HERITAGE IMPACT STATEMENT PROPOSED DESIGN MODIFICATIONS - EDUCATION BUILDING 35-39 BRIDGE STREET, SYDNEY S4.55 APPLICATION TO MODIFY SSD7484

This concise Heritage Impact Statement has been prepared to assess the impact of the proposed design modifications to the approved proposal for the Department of Education Building (Education Building) located at 35-39 Bridge Street, Sydney. The proposed design modifications, the subject of the S4.55 Application to Modify SSD7484, are required because of:

TITLE
PROPOSED ELEVATIONS - EDUCATION BUILDING - COURTYARD

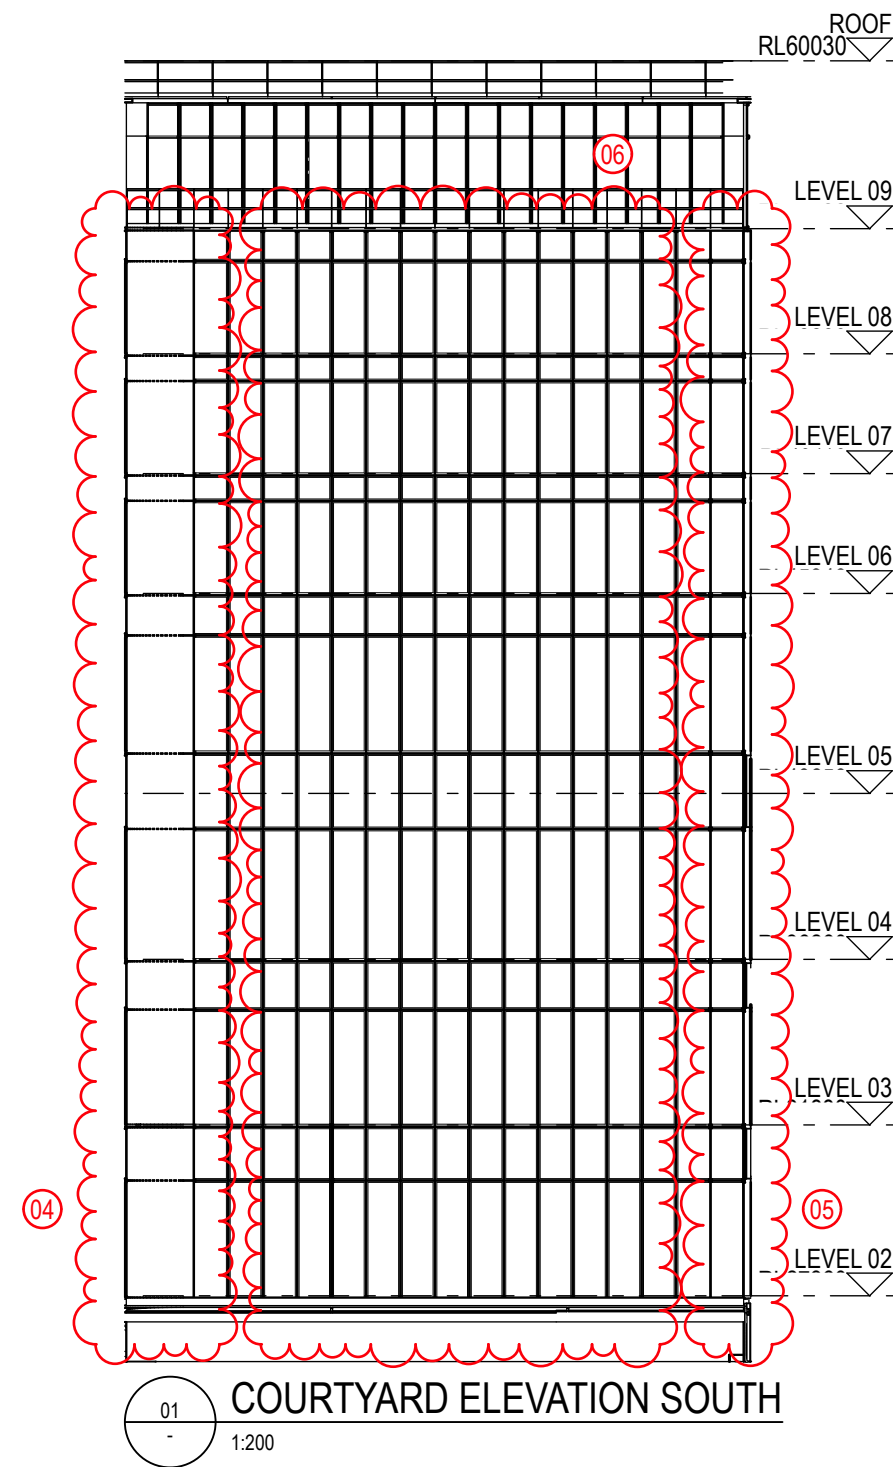
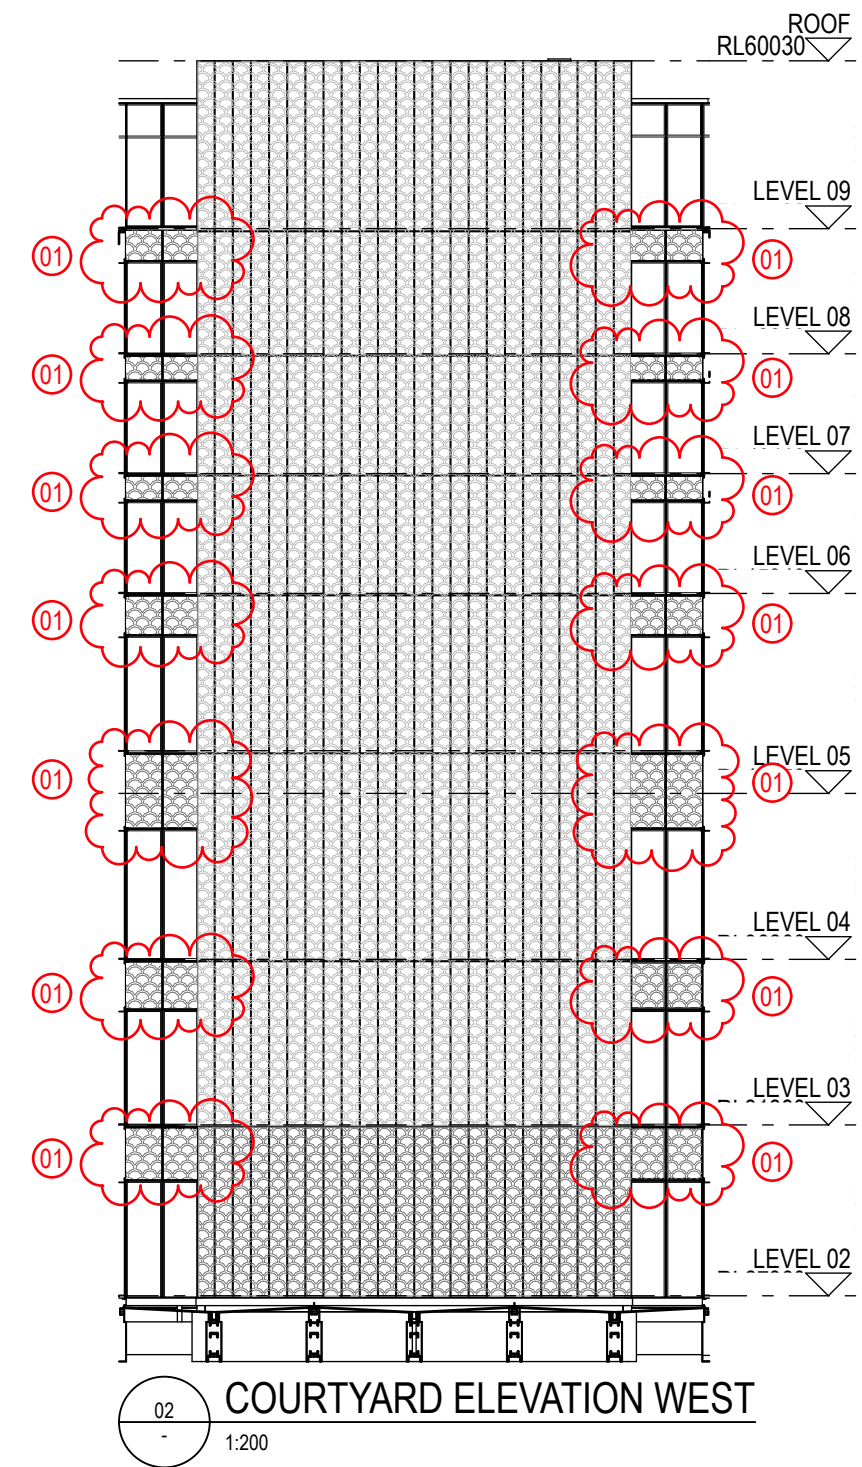
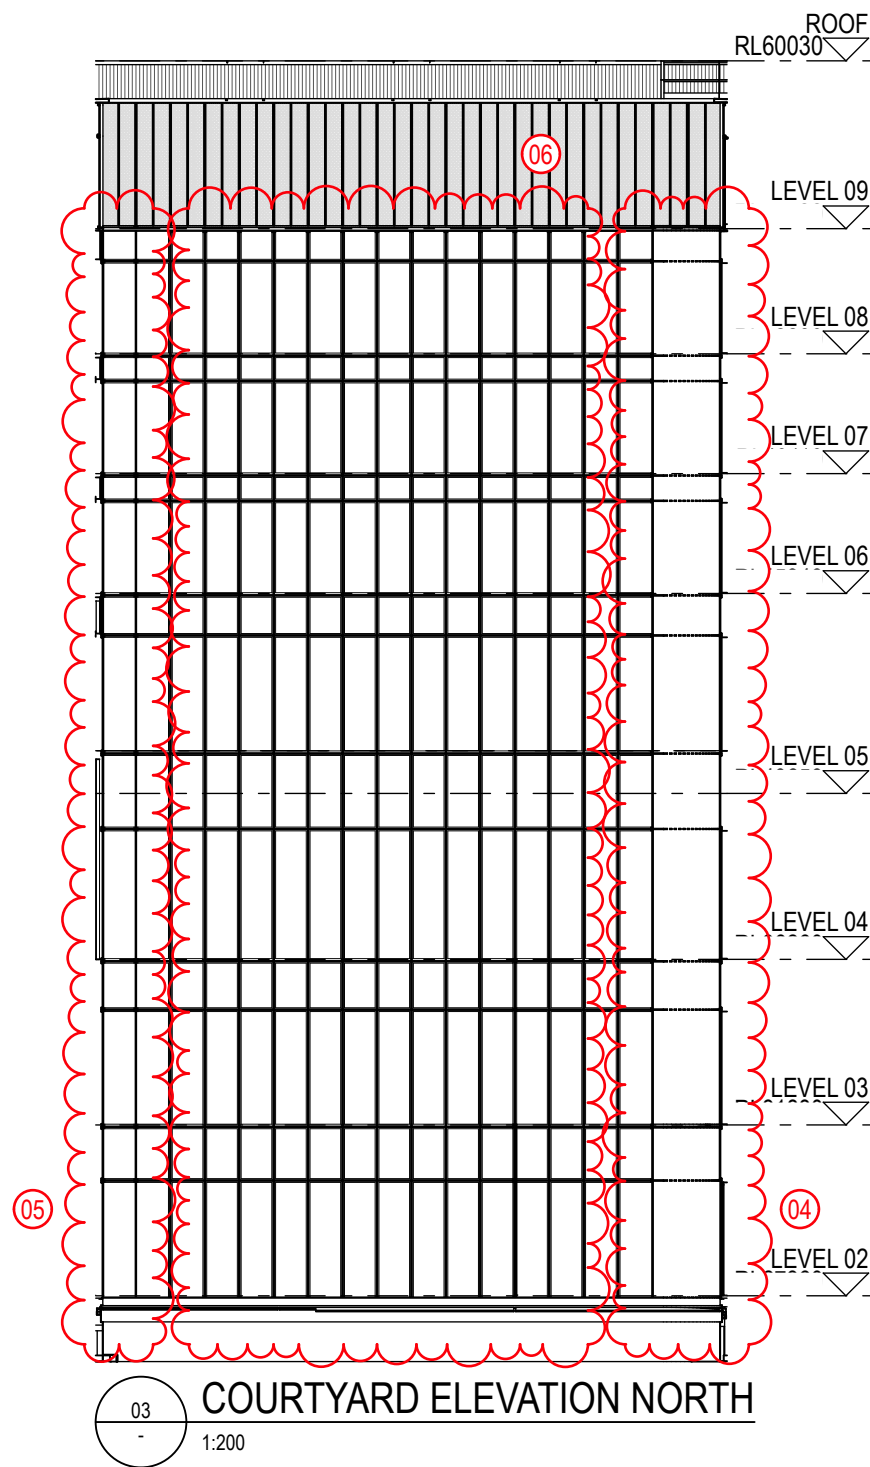
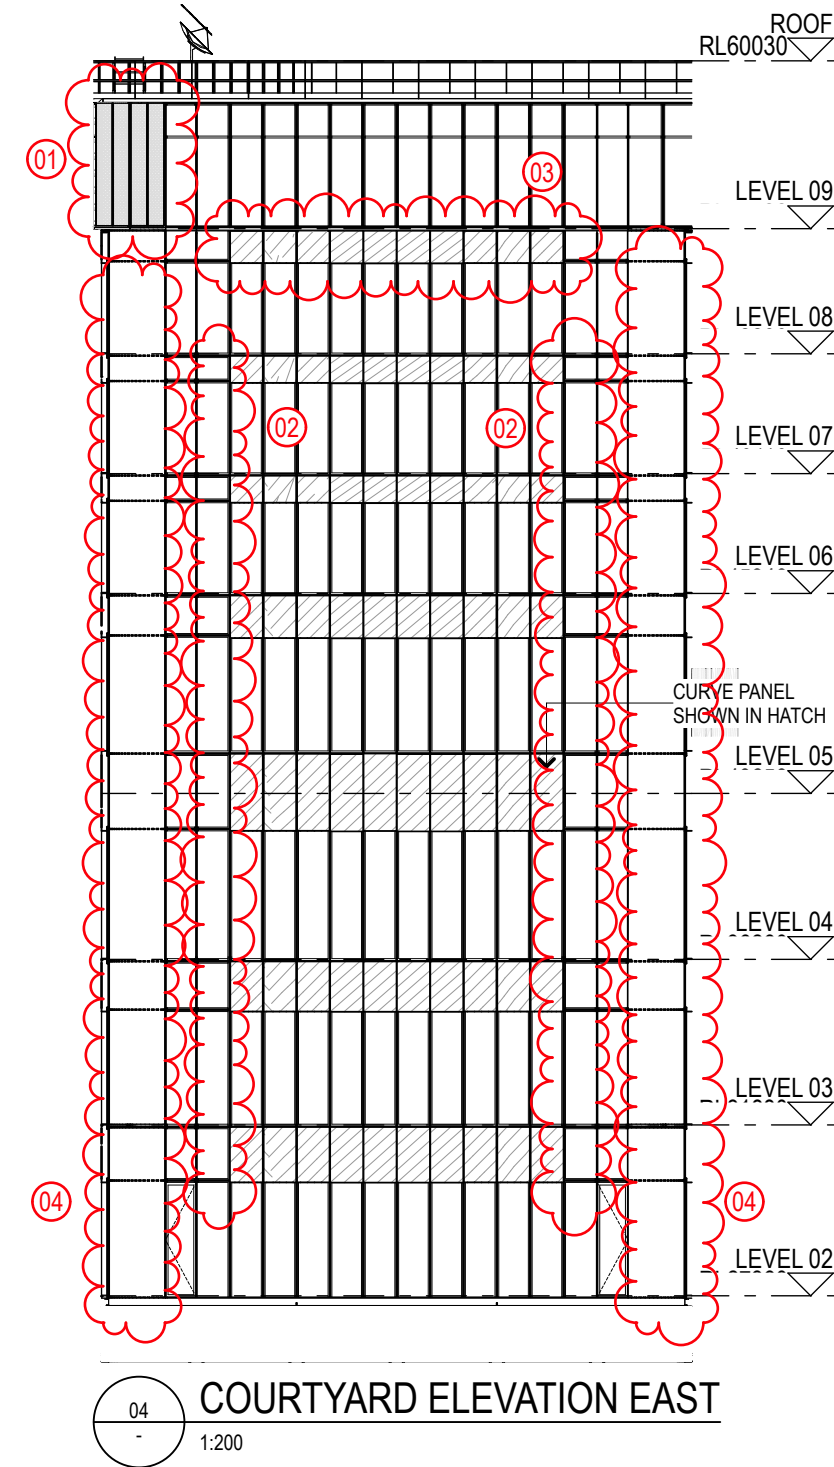
1. The louvres adjacent to the guest lift core (FTE03b) on the West courtyard elevation have been recessed into the façade and are covered by perforated cladding to conceal the louvres and maintain design intent.

2. The glass spandrels next to the louvres in item 1 (only on levels 5-8 of FTE03b) have changed from glass to recessed louvres covered by perforated cladding in order to match the adjacent louvres and maintain design intent.

3. The remaining glass spandrels next to the guest lift core (FTE03b) on the west courtyard elevation have changed to perforated cladding with backpans behind to retain a consistency in the design of the spandrel panels across the West courtyard façade.

5. The louvres on level 9 East elevation of the courtyard (FTE09) have been replaced by glass spandrels to avoid any visible louvres on the glass facade. To avoid visible louvers on the full height glass facade, the required louvres have been located to the furthest north glass panels of the east elevation. The proprietary mechanical louvres are concealed by perforated fluted cladding which matches the level 9 cooling tower facade adjacent.

6. Two awning panels have been removed on every level on the East courtyard elevation from levels 2-7 (one on each side of current awnings – 2 awnings on 6 levels = 12 awning panels removed) and a new awning consisting of 10 panels has been introduced. In order to retain the same design language as the lower levels and to complete the 'mirrored' glass box concept' an awning was introduced to level 8.

7. The louvres on level 2 of the Eastern elevation of the courtyard (FTE03b) have each moved one panel to the right to create symmetry and even airflow through the level 2 corridor.

10. Louvres have been introduced to the Northern and Southern faces of the guest lift core from levels 5-9 due to design development for air flow purposes and are covered behind perforated cladding to conceal the mechanical louvres and match the design of the East face of the lift core on level 2.

11. The internal corners of the courtyard on the west elevation have changed from curved glass corners to squared corners as the 1500mm curved glass radius would clash with the louvres.
